***MODIFICATION REQUEST:
Stage 1 Mixed Commercial and
Retail Development
6 Australia Avenue, Sydney
Olympic Park
(MP 10_0168 MOD 1)***

**Modified basement car park, minor
design changes and exclusion of part
construction of East West Street**

**Director-General's
Environmental Assessment Report
Section 75W of the
*Environmental Planning and
Assessment Act 1979***

August 2013

GFA PLANS

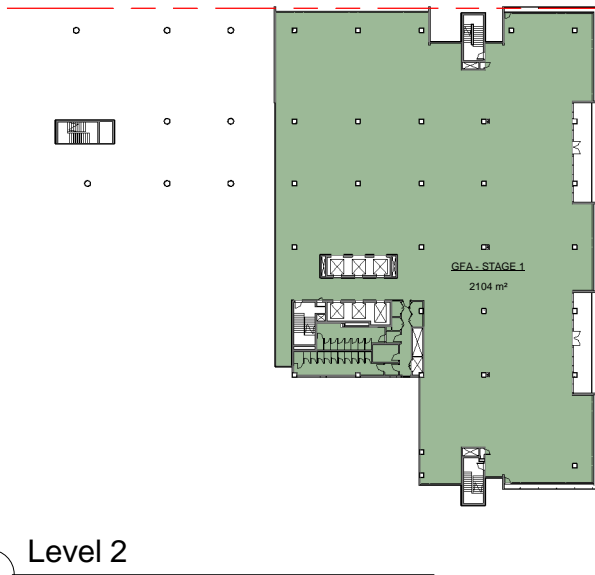
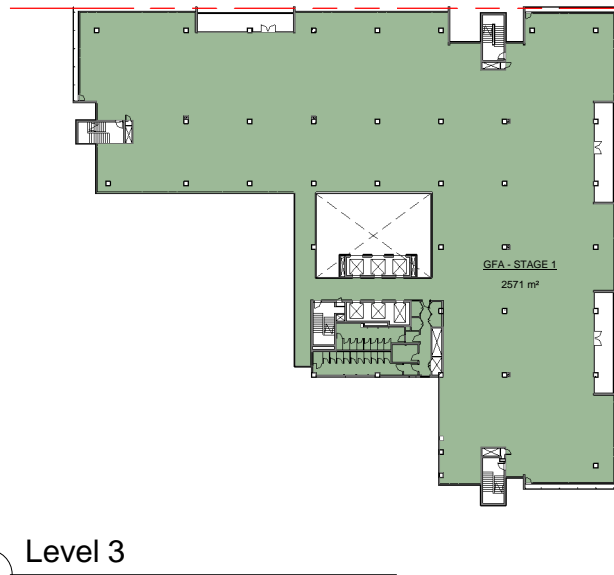
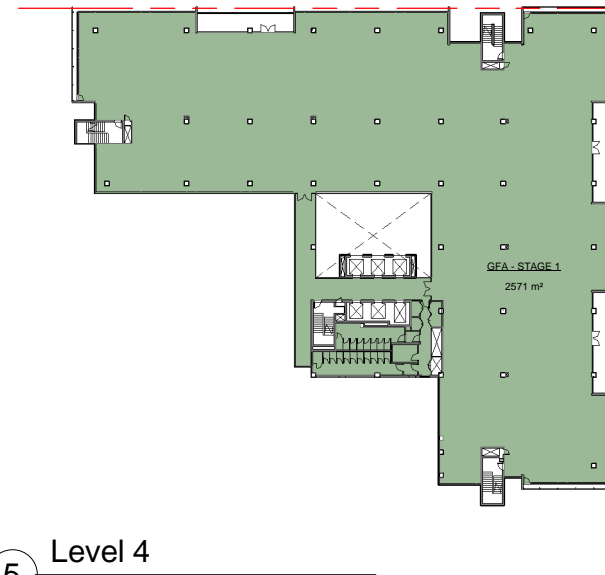
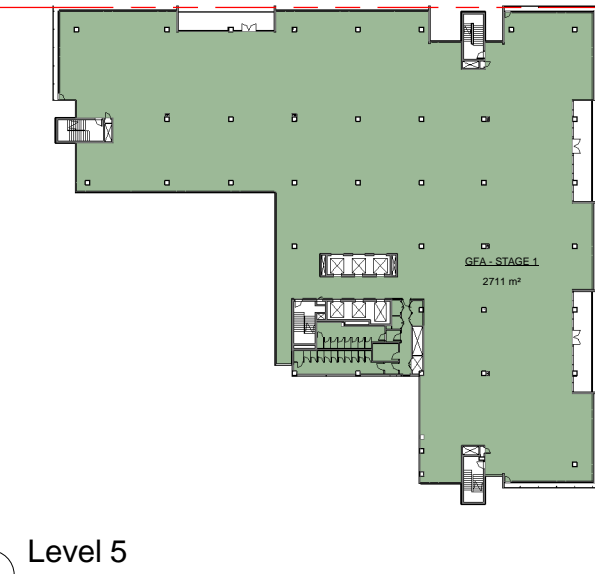
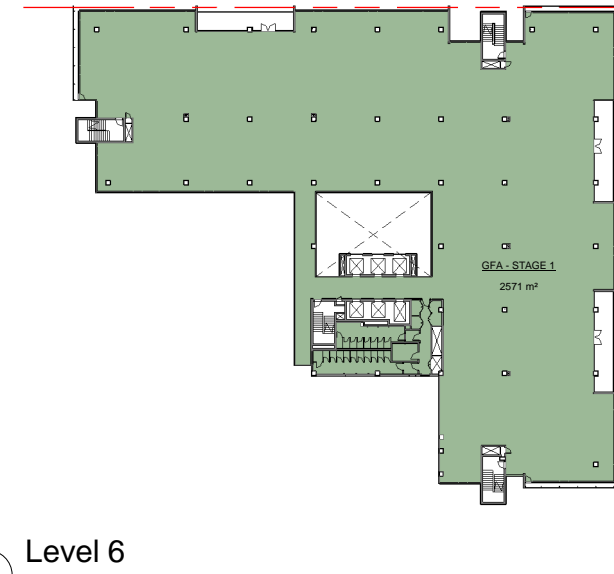
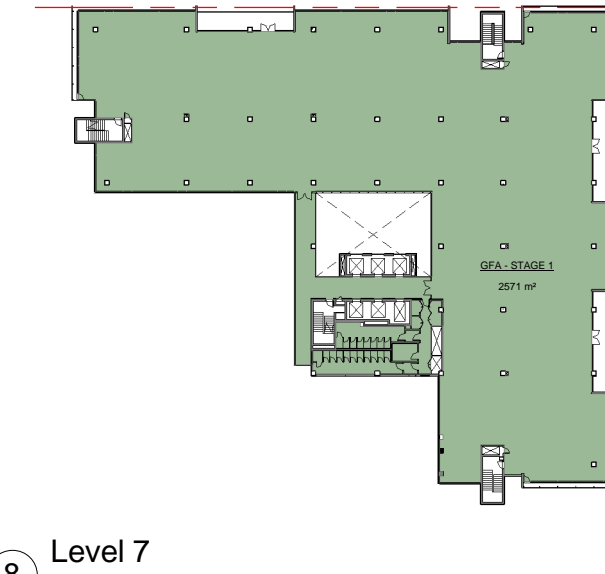
The minor floorspace variations are generally contained within the approved building footprint and envelope and would have minimal environmental impacts as the additional floor area is comprised of conversion of the atrium space on Levels 2 and 5 to floor area. This potentially results in less natural light penetrating the lower levels. However, the department considers natural light penetration is adequate as the building generally complies with the recommended maximum depth of 25 metres in Master Plan 2030, except for the two small areas which have been converted from atrium space to floor area. The demolition of the existing warehouse building results in an overall reduction of floor space across the site and therefore even with the minor floor space increase, the FSR for the site of 1.46:1 complies with the maximum 3.5:1 permitted in the MD SEPP. Should Stages 1A and 2 be approved as proposed, the total FSR for Site 43/44 will be 3.47:1.
